SUBJECT: Engineering Review Comment
Mountain View Electric Association Inc. (MVEA)

Project Name: Willow Springs West Annexation 2

Project Number: 20260223

Description: Proposed development of 38 residential lots located near Rickenbacker Ave. in Township 11S, Range 67W, Section 27.

WILLOW SPRINGS ANNEXATION No. 3

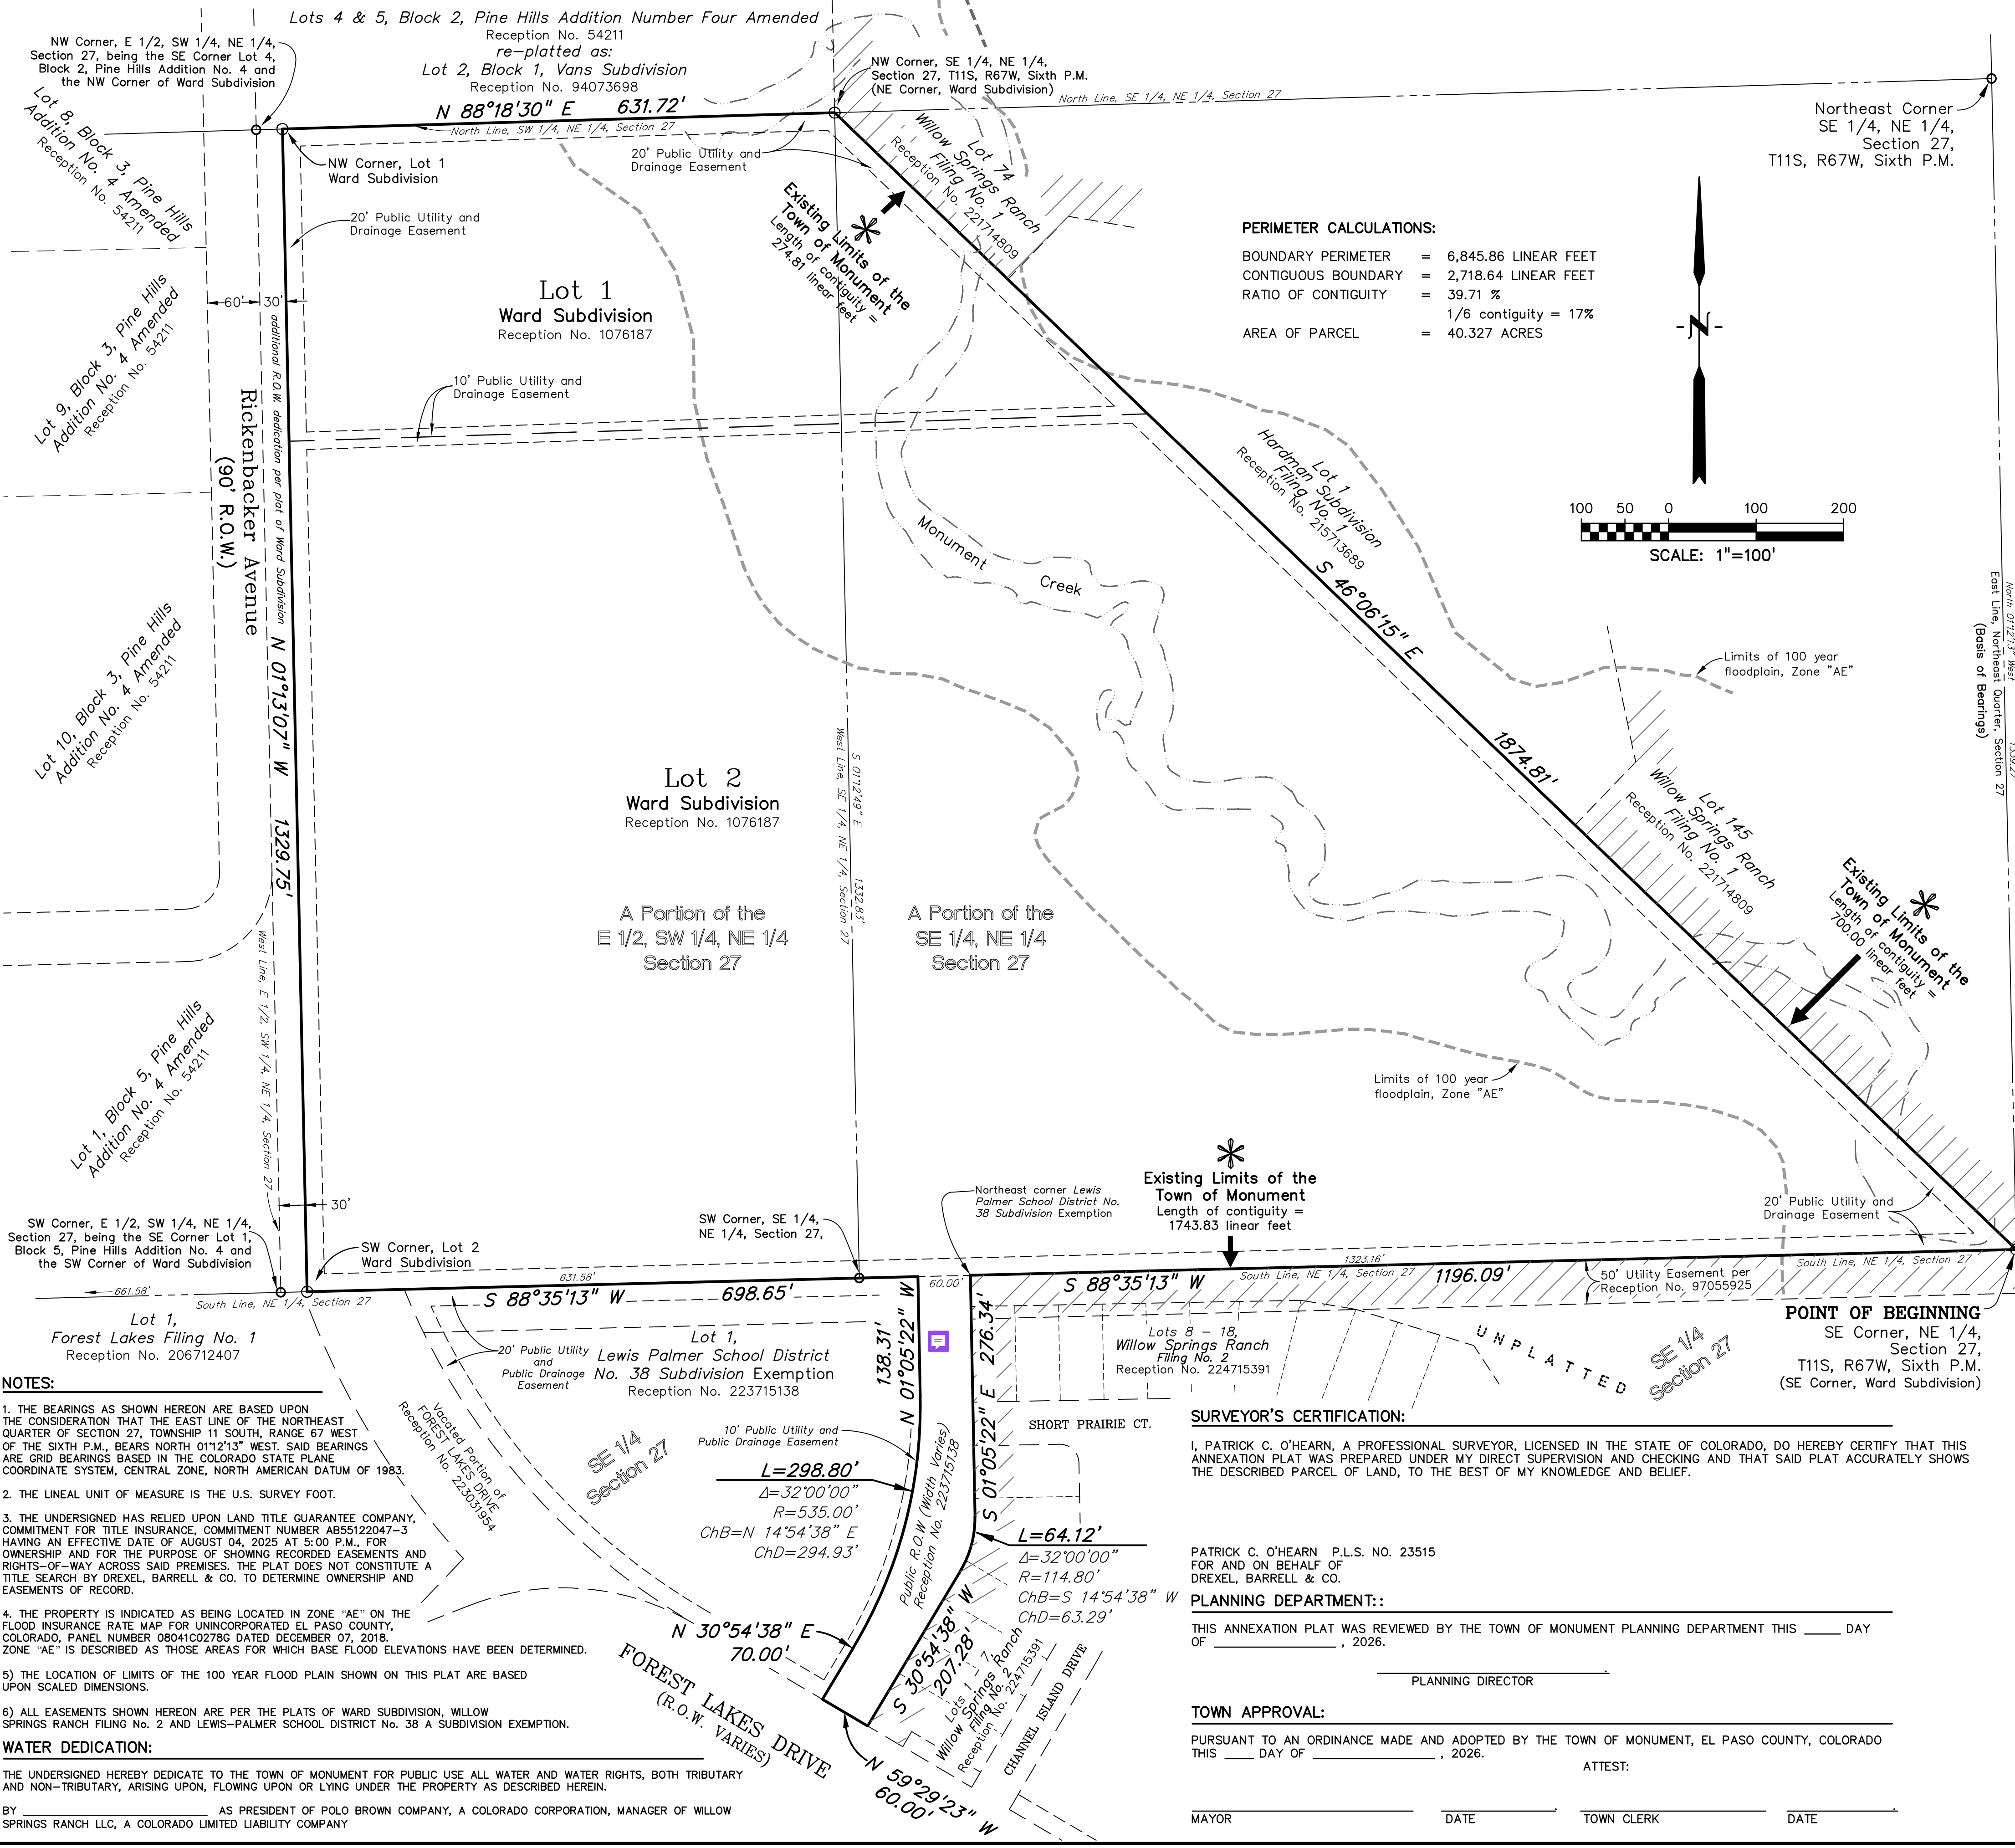
MVEA requests a ten (10) foot front, side, and rear lot utility easement and all tracts, along with a twenty (20) foot exterior utility easement on the plat. MVEA also requests the platting of MVEA's existing facilities with easements on the plat. Additional easements may be required.
